Application number: 2020/91978	
What is the application for?:	Part demolition of boundary wall to form new off road parking space (within a Co
Address of the site or building:	22, Town Head, Honley, Holmfirth, HD9 6BW
Postcode:	WF14 8EA

User comments

SITE PLAN AS PROPOSED

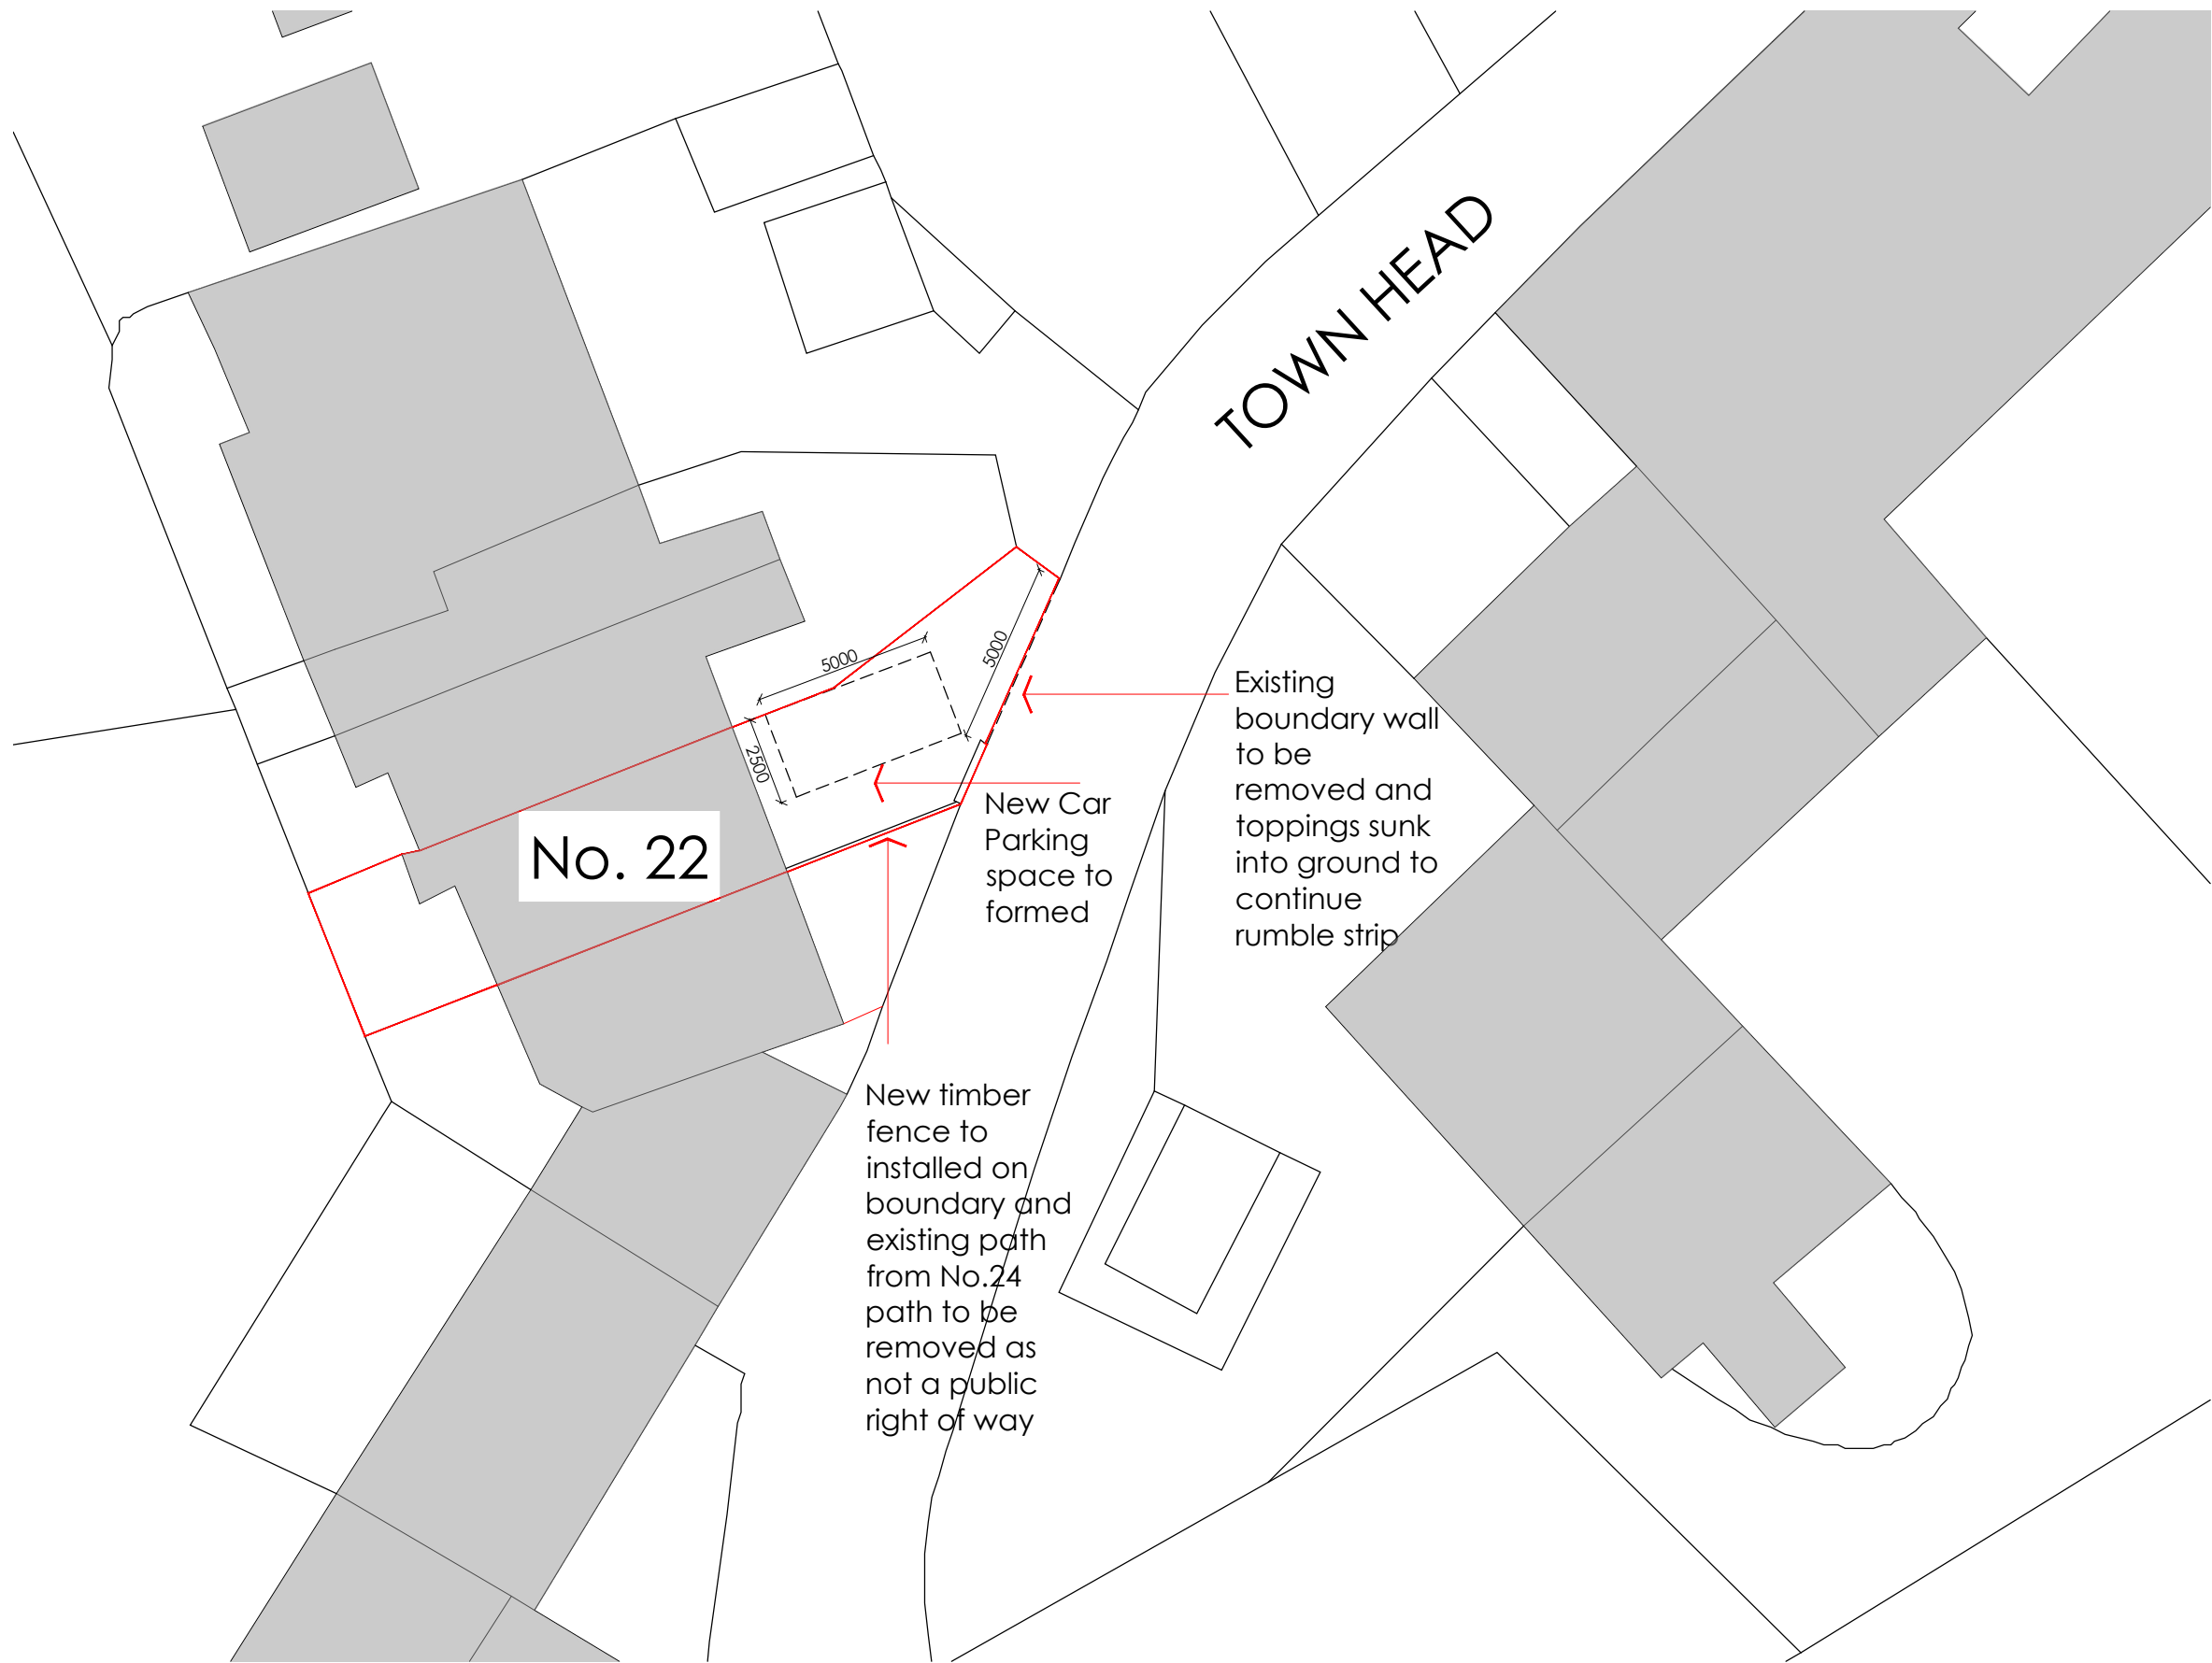
Type of comment: An objection
i do not want to see a wall knocked down for off road parking the wall is part of the character of the village you allow one wall to be knocked down then the rest will follow.
